Reference: 23.464r03v02

19 December 2024

**RE Proposed Construction and Demolition (C & D) Waste Management Facility (SSD-62855708)
Response to Goodman Submission**

1 TRUCK DRIVEWAY SECTION  
1 : 100

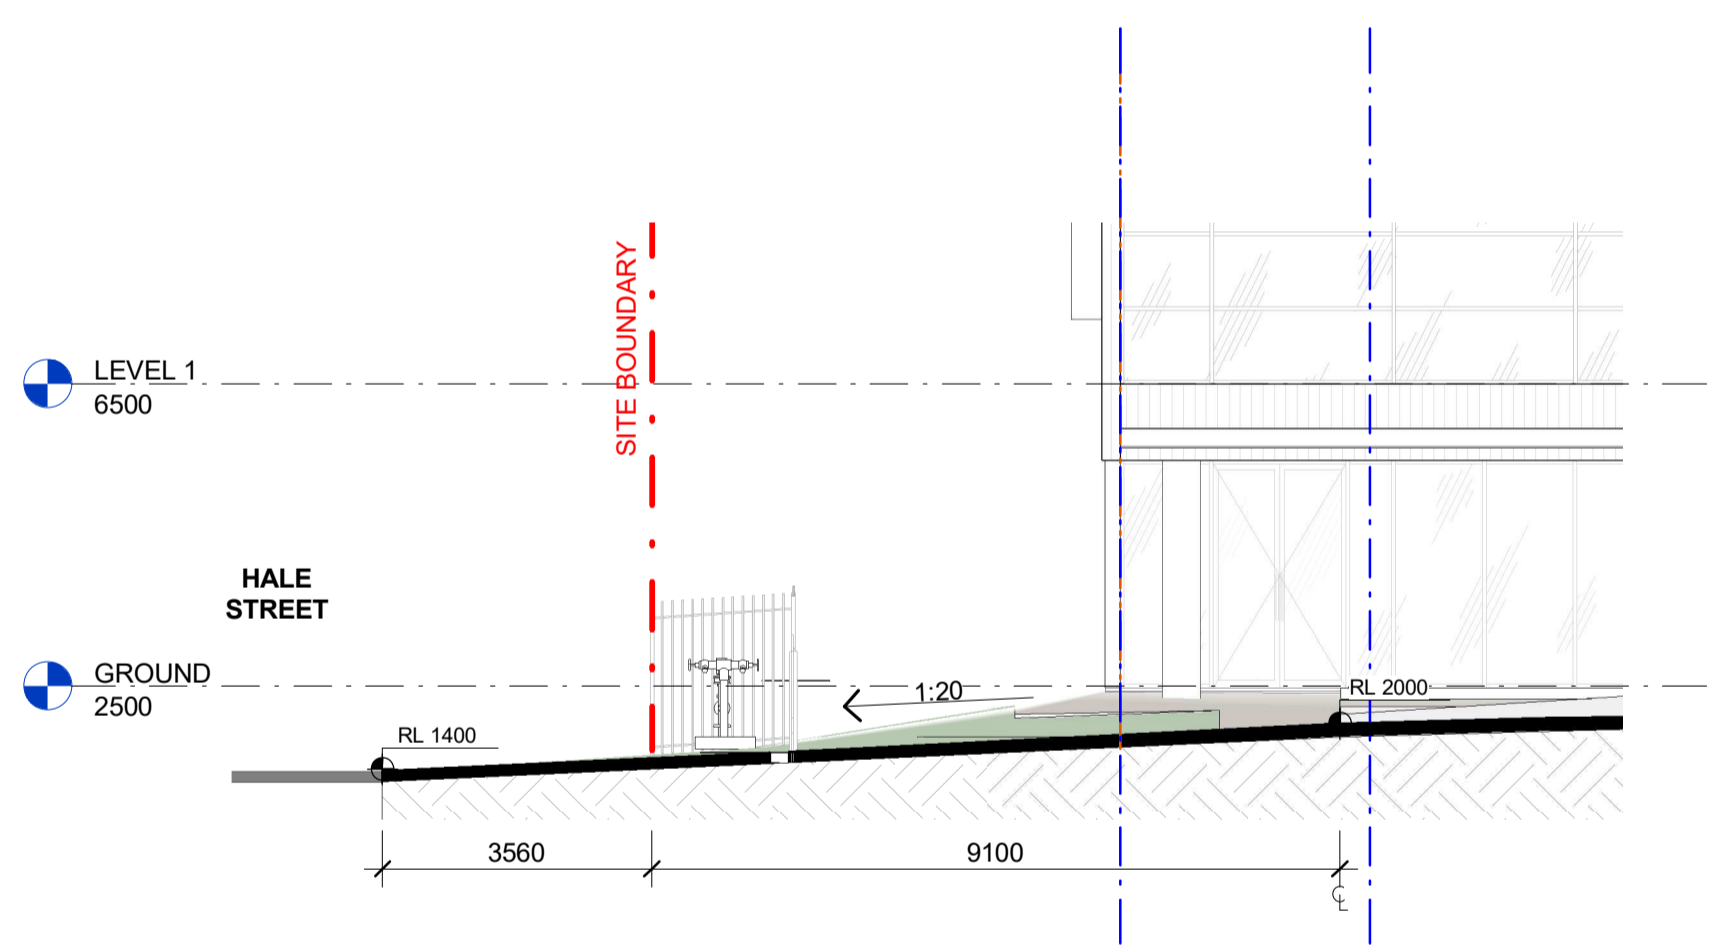
- *The swept path analysis shows that exiting B-double vehicles might encroach onto parked vehicles on Hale Street's southern side and cross into opposing lanes when entering, posing potential safety concerns.*

- *The Proposal's 29-meter-wide truck access is less than 20 meters from the Hale/Luland Street roundabout. This proximity raises safety issues, highlighting the need to include the roundabout in the assessment.*

The swept path analysis provided in the latest submission clearly demonstrates B-double vehicles do not encroach onto parked vehicles on Hale Street's southern side.

Vehicles turning out of the site will need to cross opposing lanes and give way to vehicles on the public road under Australian Road Rules (ARR). There are no safety concerns with vehicle right turn movements that would occur in every driveway, including heavy vehicle movements at Goodman's Port Air Industrial Estate (34 Luland Street & 1&1A Hale Street / Lot 100 DP1213007) when heavy vehicles including B-doubles need to turn right in or out of the Goodman's site.

The proposed truck access location has been strategically positioned to satisfy site operational requirements and is located as far practicable from Foreshore Road being the critical classified road to optimise road network capacity.

The proposed position of the driveways has also been satisfactorily designed in accordance with AS 2890.1 (2004) and AS 2890.2 (2018) and will operate safely and efficiently.
